May 12, 2020

Reference: Engineering Services
73 Farrow Court (Lot 11)
Harnett County, NC
Project No.: 2001-020310

FOUNDATION PLAN
1/4" = 1'-0"

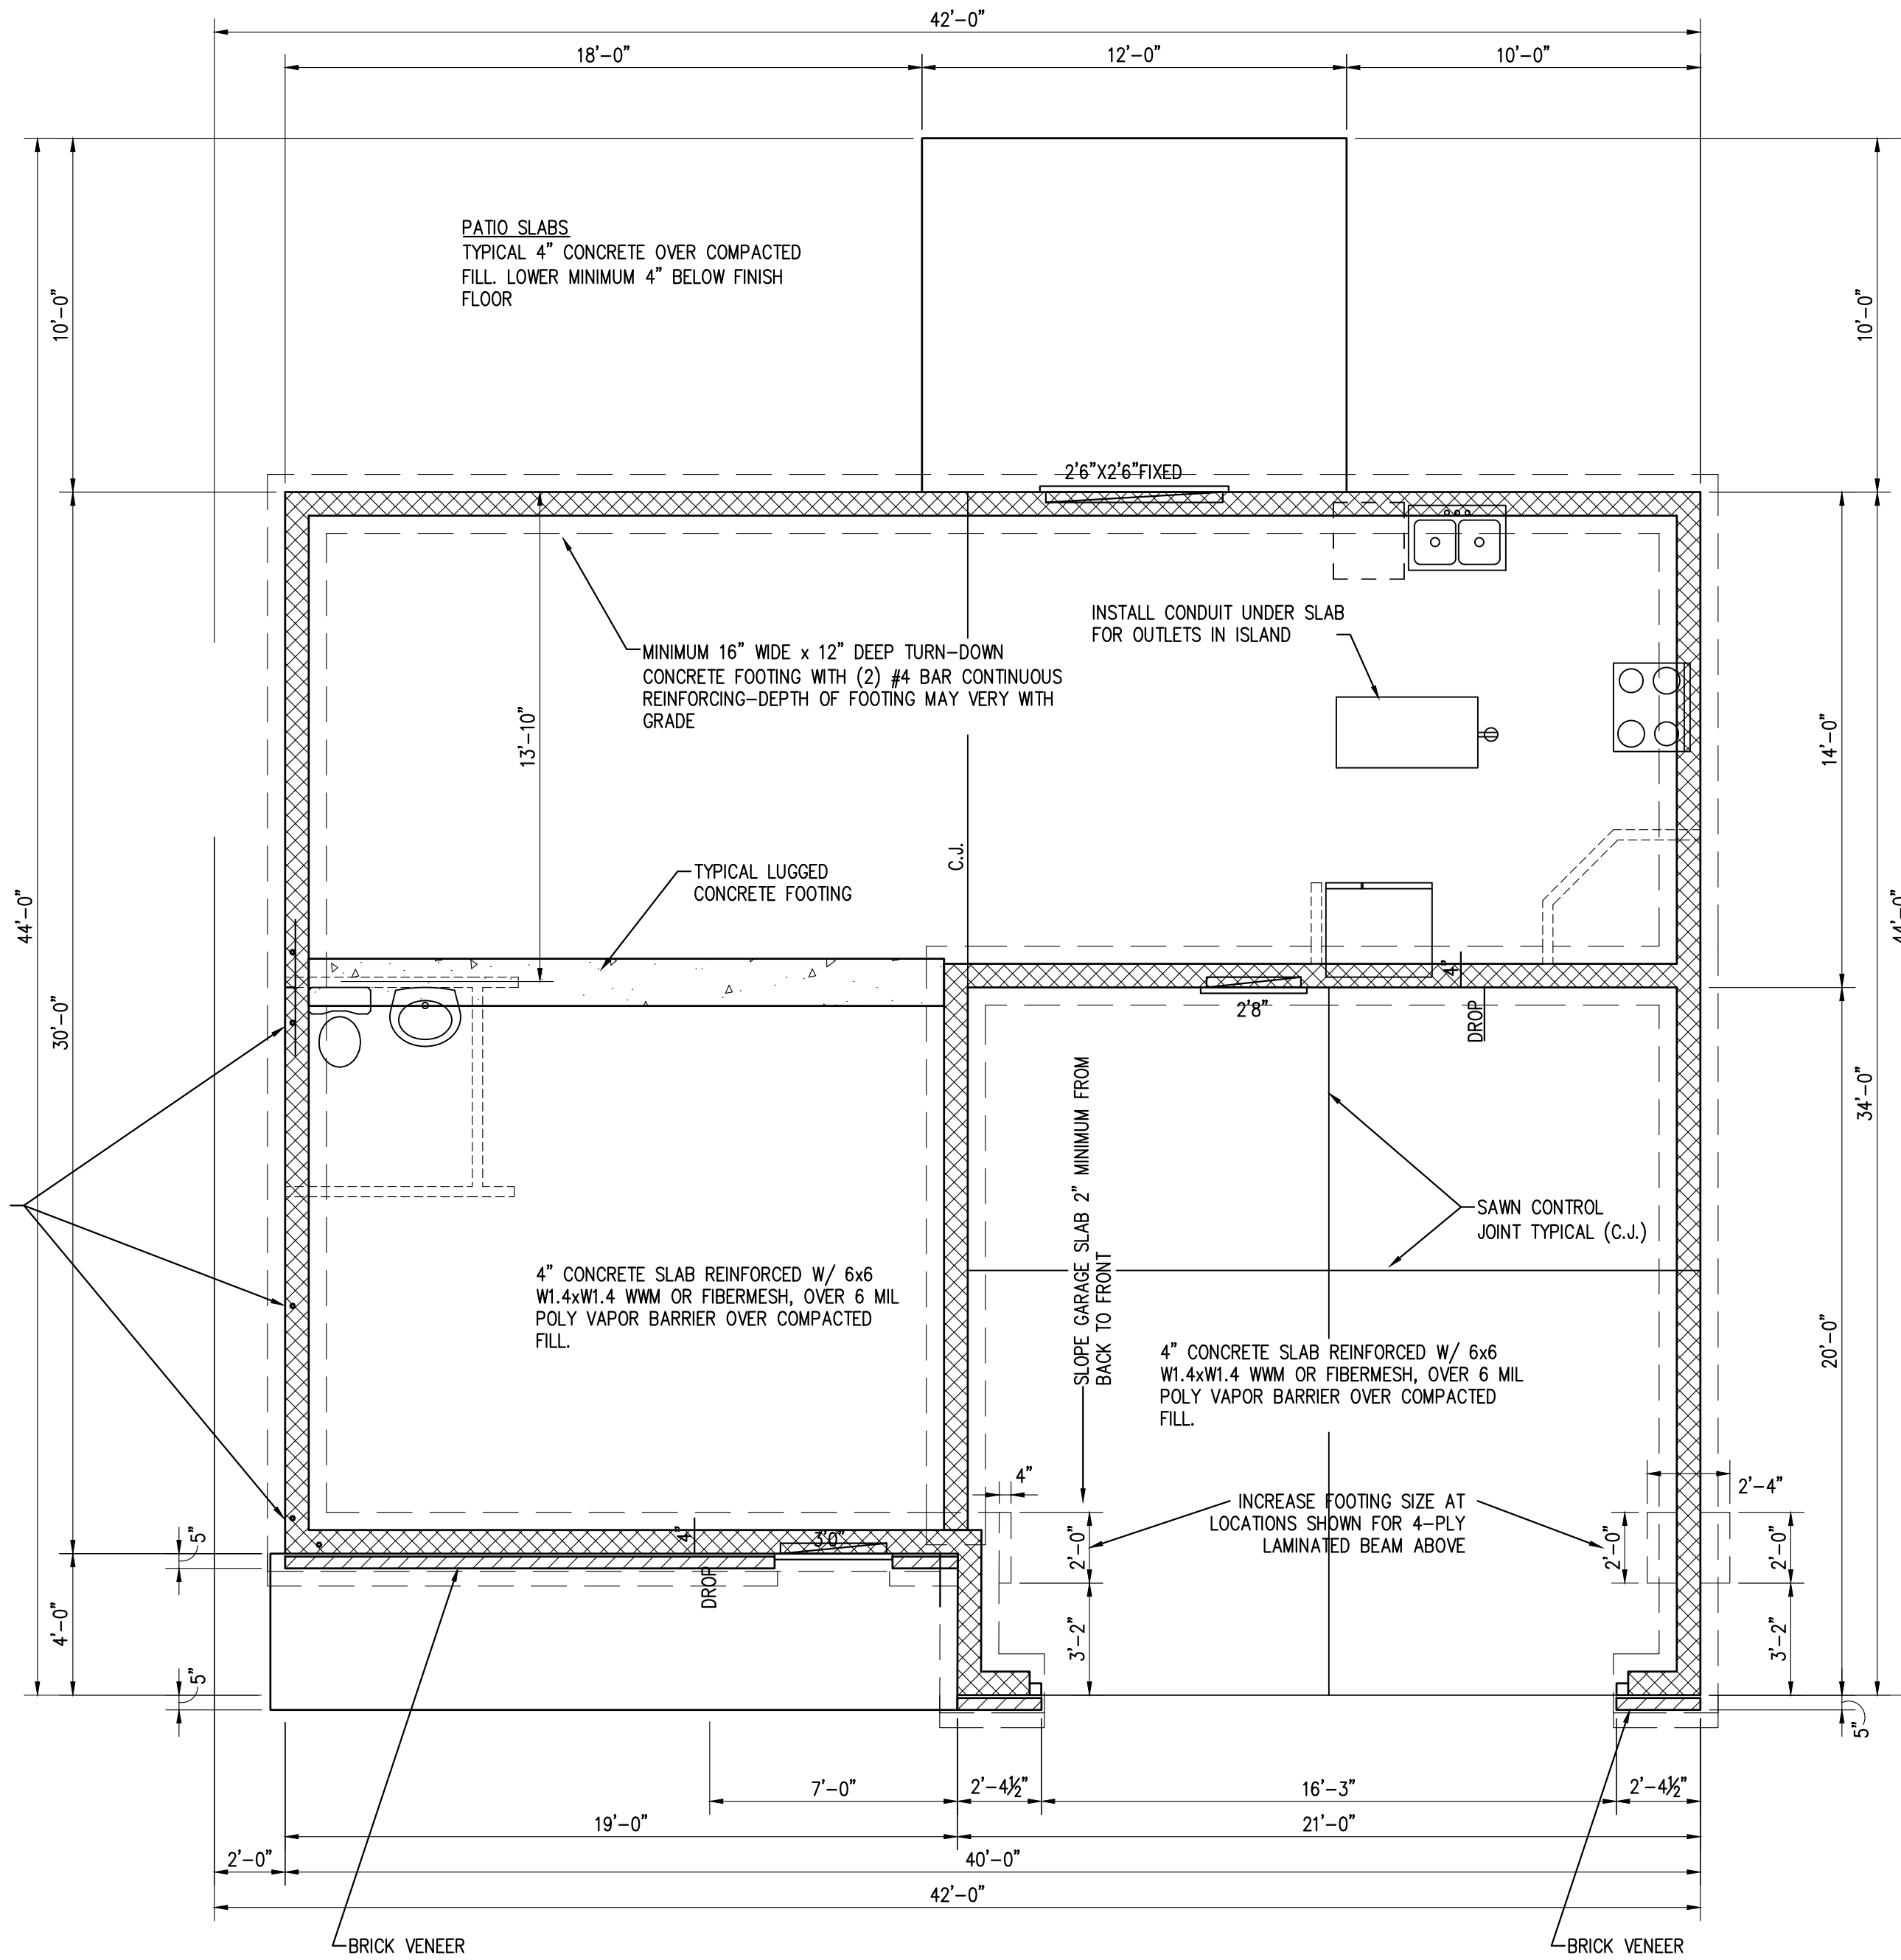
- 1) Recommend a repair for the proposed footing to accommodate the “stump hole” that was encountered within the existing rear wall footing excavation.

- 1) Based on our conversations with the contractor and supplemental analyses, it was recommended that the section of footing containing the “stump hole” be reinforced with (3) #3 rebars. The #3 rebars should extend at least 6 feet beyond the edge of the stump excavation, each way in the wall footing excavation. The existing stump excavation may be backfilled with additional concrete. These recommended repairs/enhancements will be structurally adequate to support the anticipated loading conditions.
